Our Ref: EN010012

Date: 25 February 2021

Application by NNB Generation Company (SZC) Limited for an Order Granting Development Consent for The Sizewell C Project

Request for further information

DRAWING NO:
SZC-SZ0100-XX-000-DRW-100205

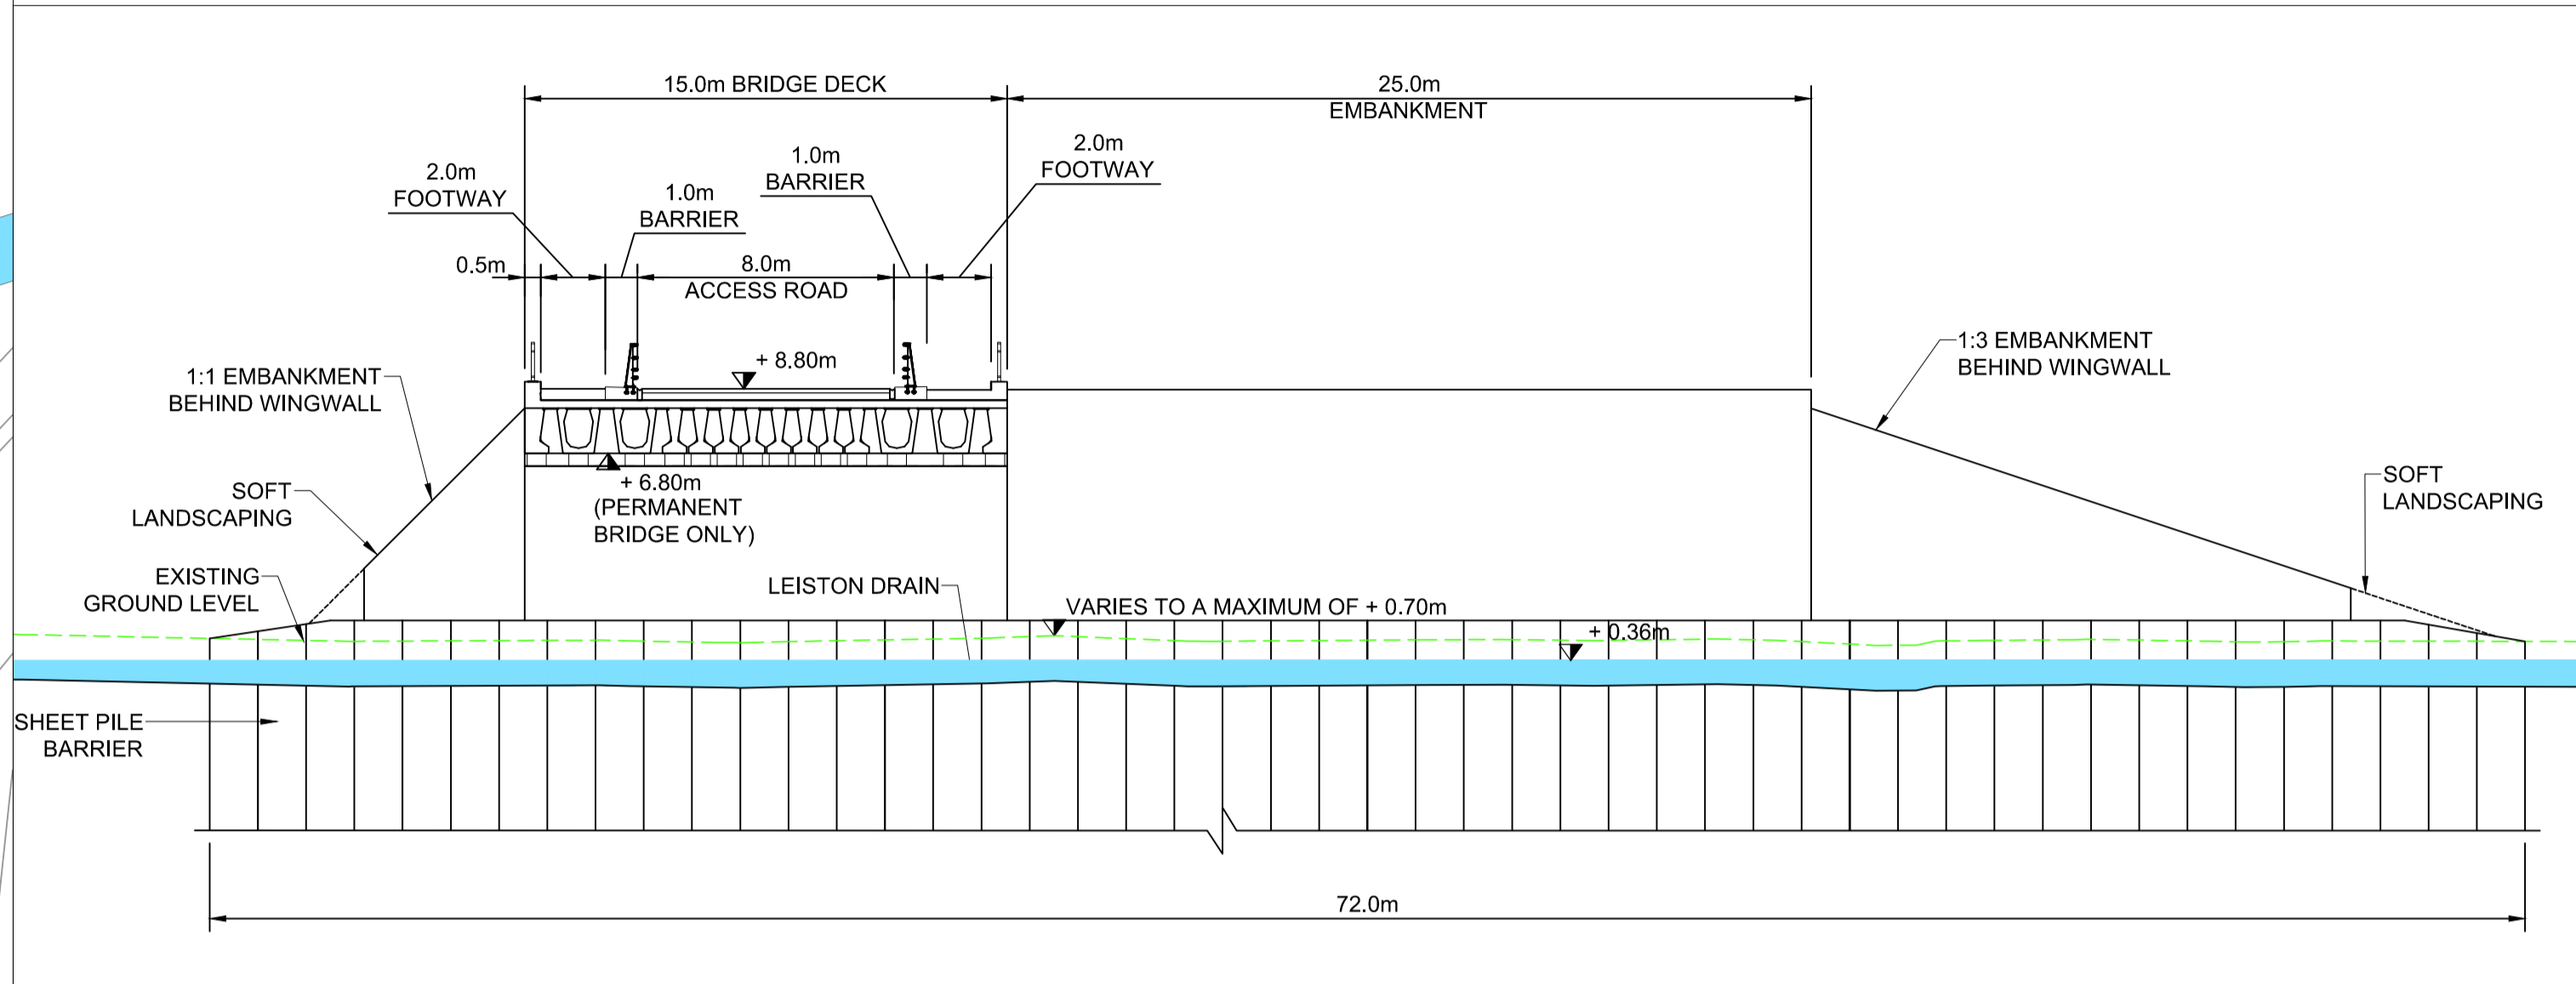
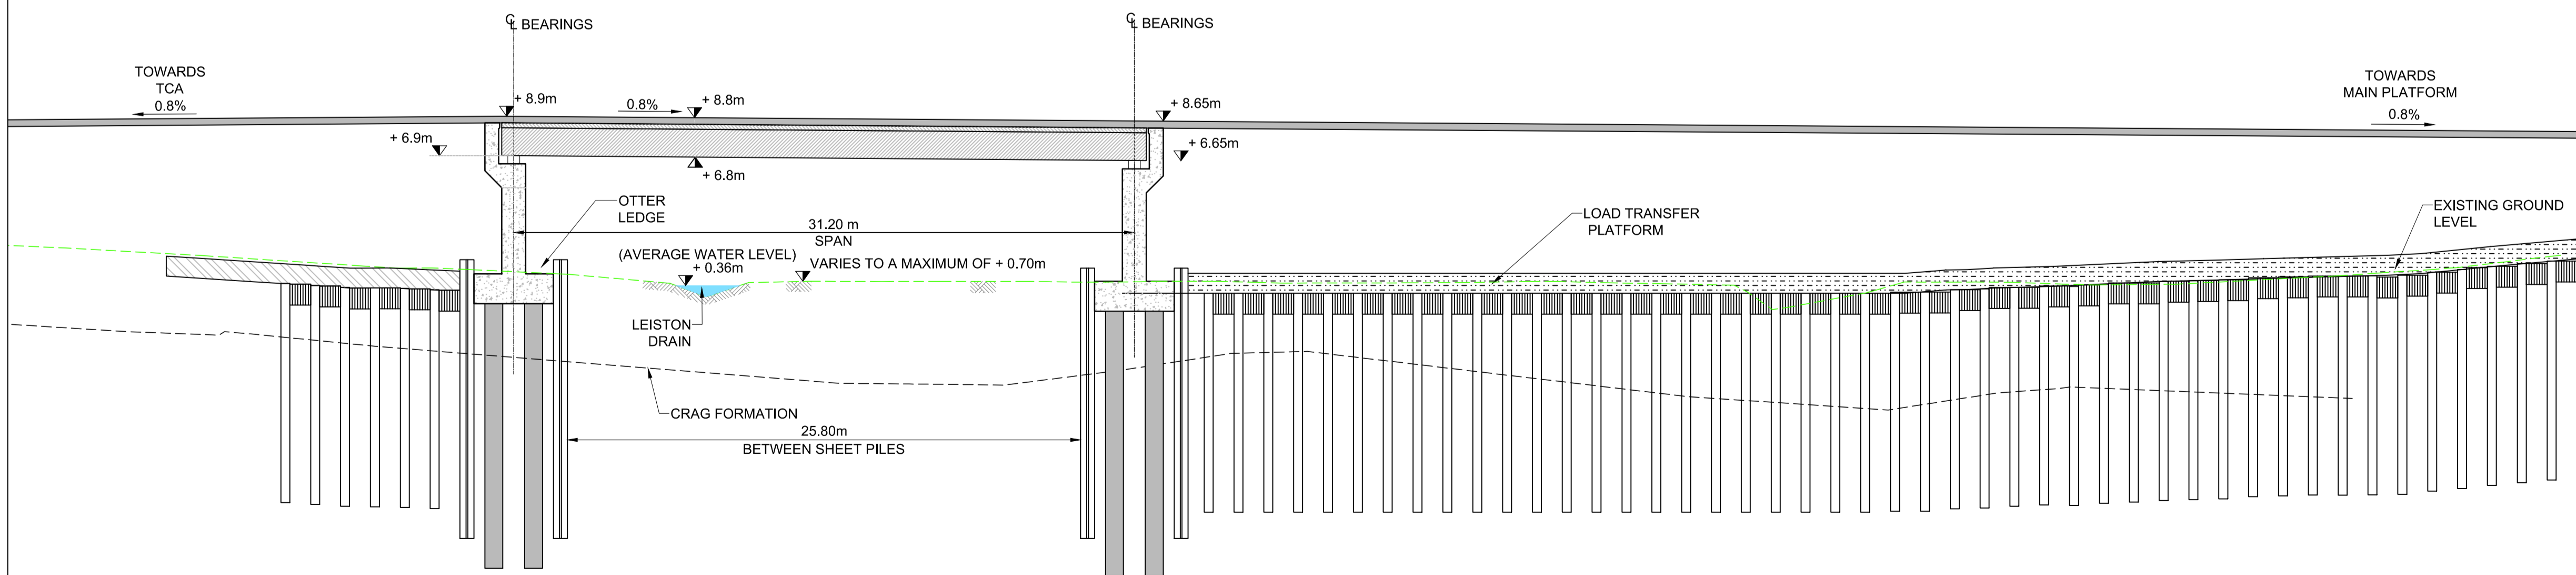
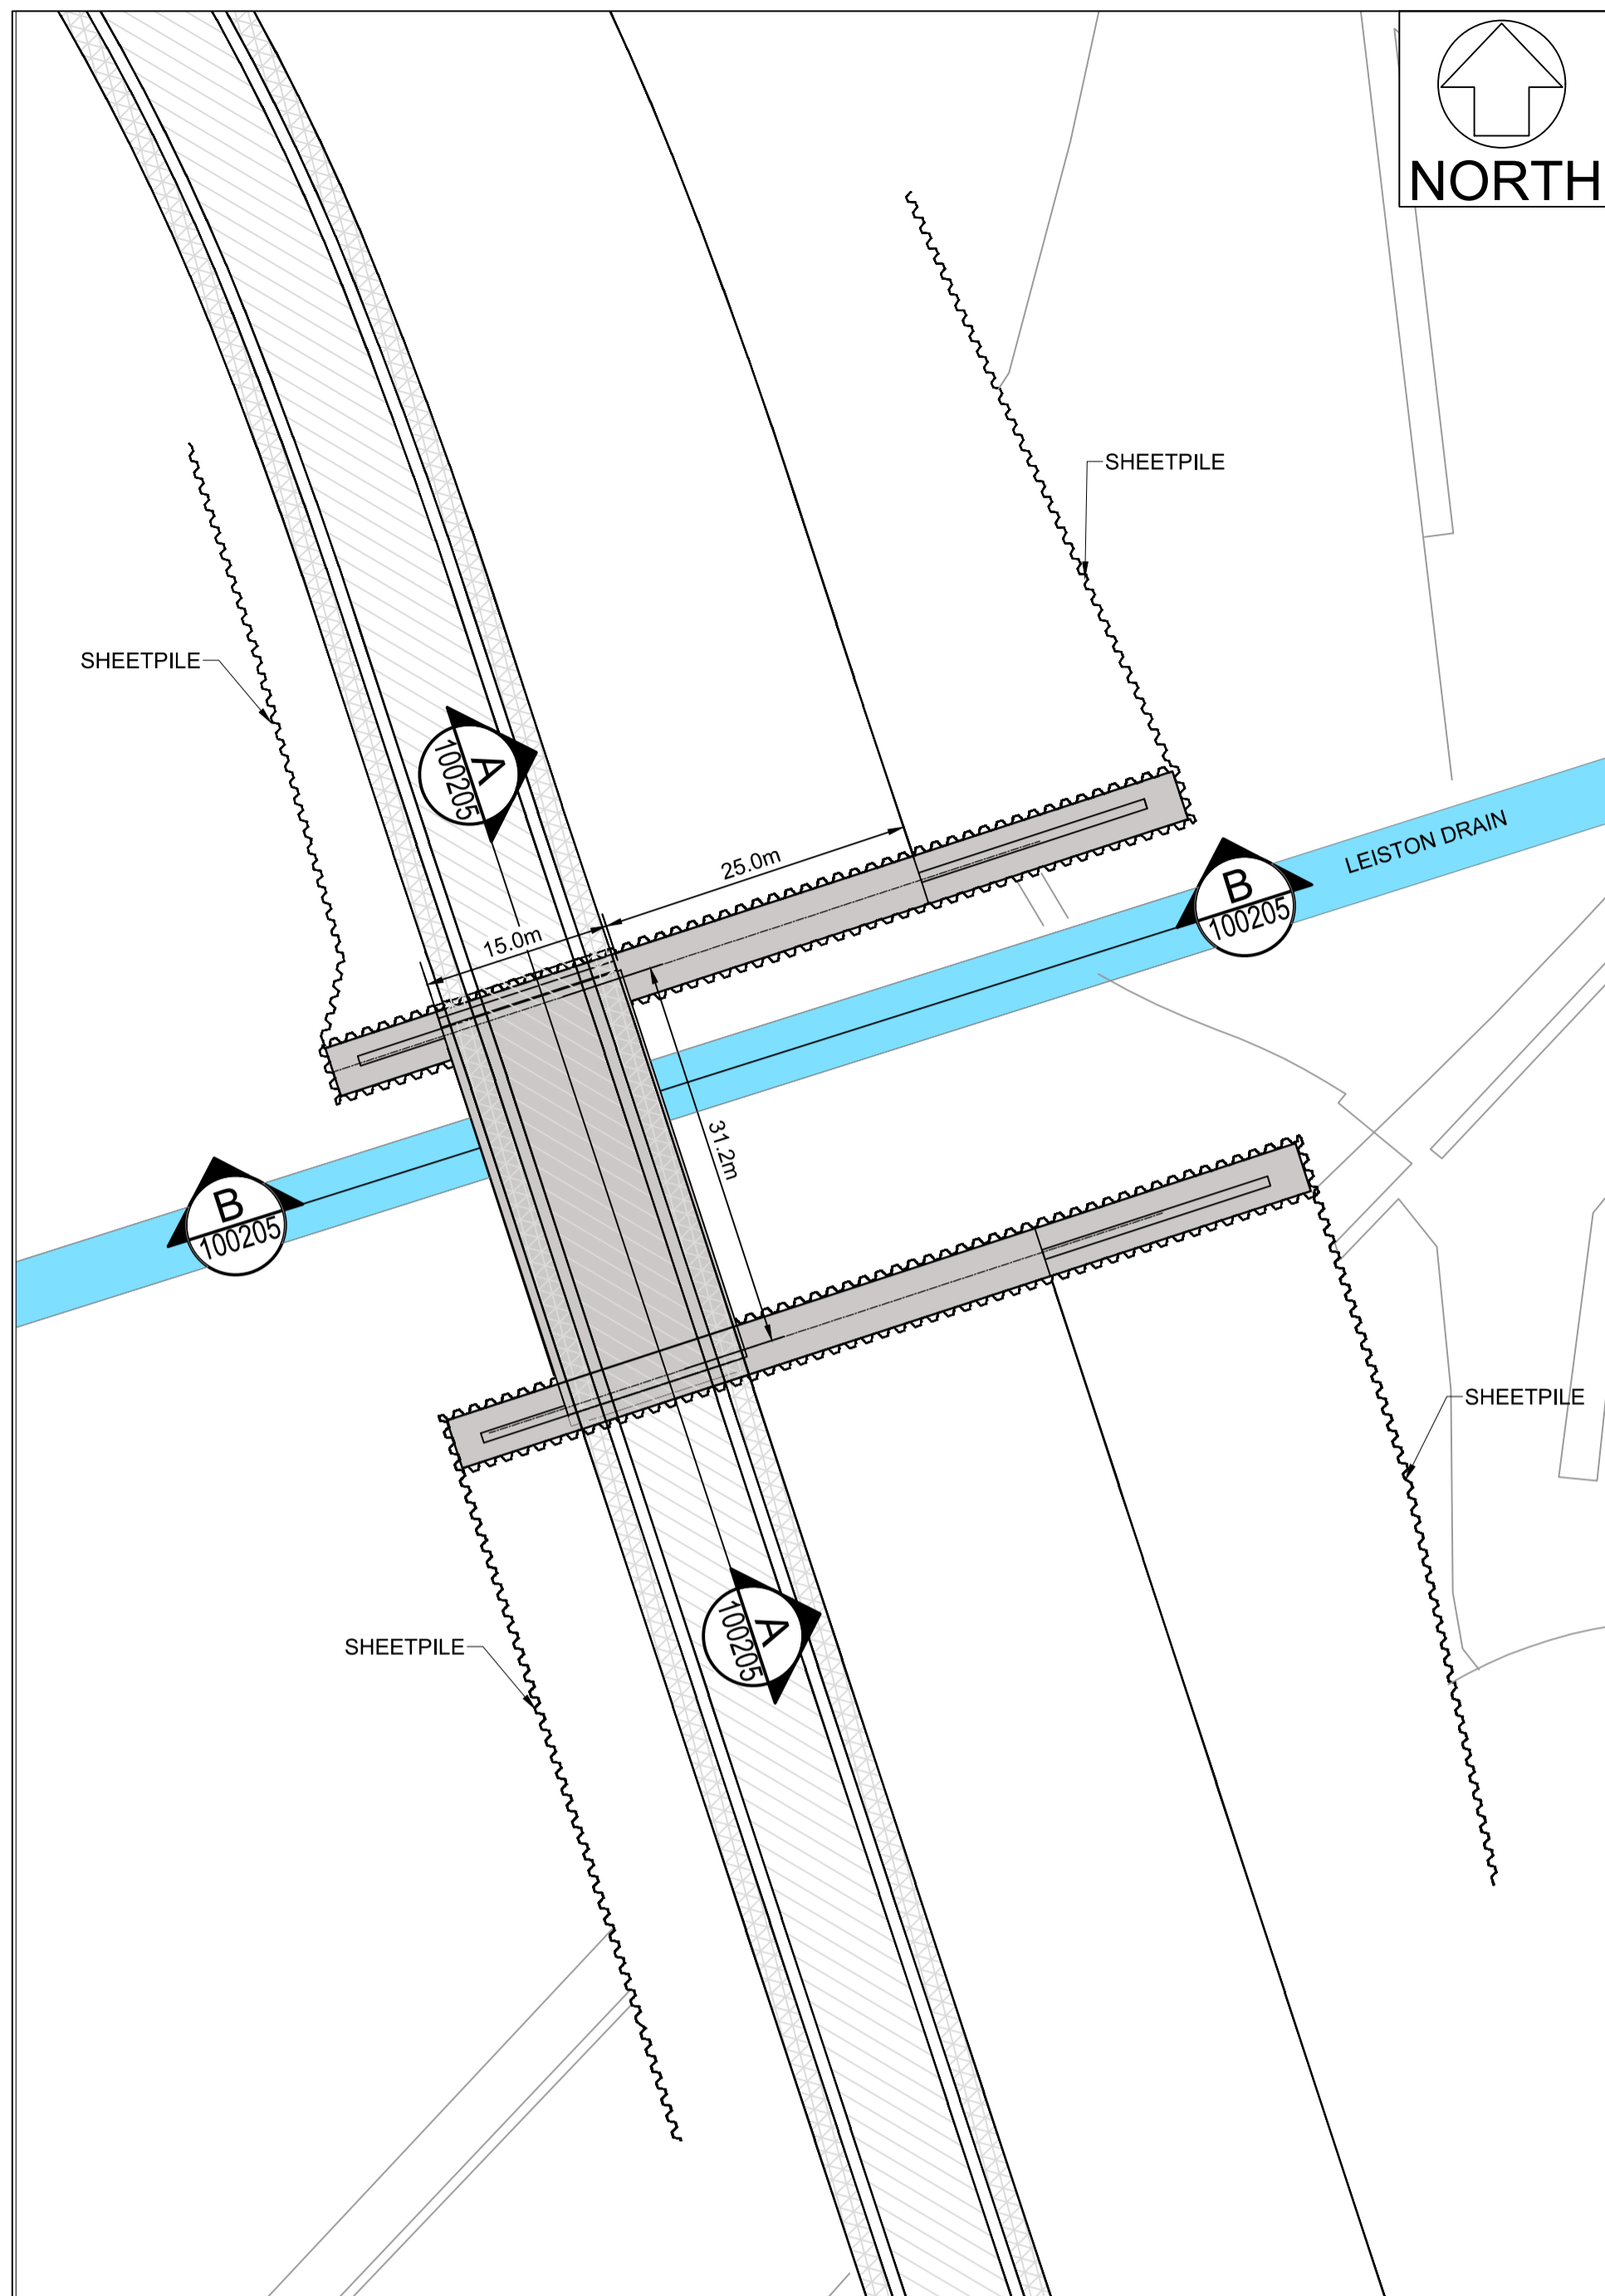
2. **Change number 6**, Change to the SSSI crossing design to a single span bridge with embankments.

Please provide the following:

- A detailed plan of the permanent crossing of the SSSI and its connection to the main site;
- A detailed plan of the SSSI crossing showing the additional temporary haul road in place.
- A detailed plan showing the temporary bailey bridges
- A cross section perpendicular to the longitudinal section that is shown in Plate 3.2 in [[AS-157](#)];
- A permanent access road cross section showing the widths of carriageway and locations of the barriers to correct scale;
- A representative view / elevation of the crossing from the west side looking east; and
- If lighting is proposed to be provided a revised version of Figure 2.2.15 in [[AS-190](#)] and related views/ sections requested above.

Please also provide detailed plans, including cross and longitudinal sections, of the initial SSSI crossing as submitted in the original application.
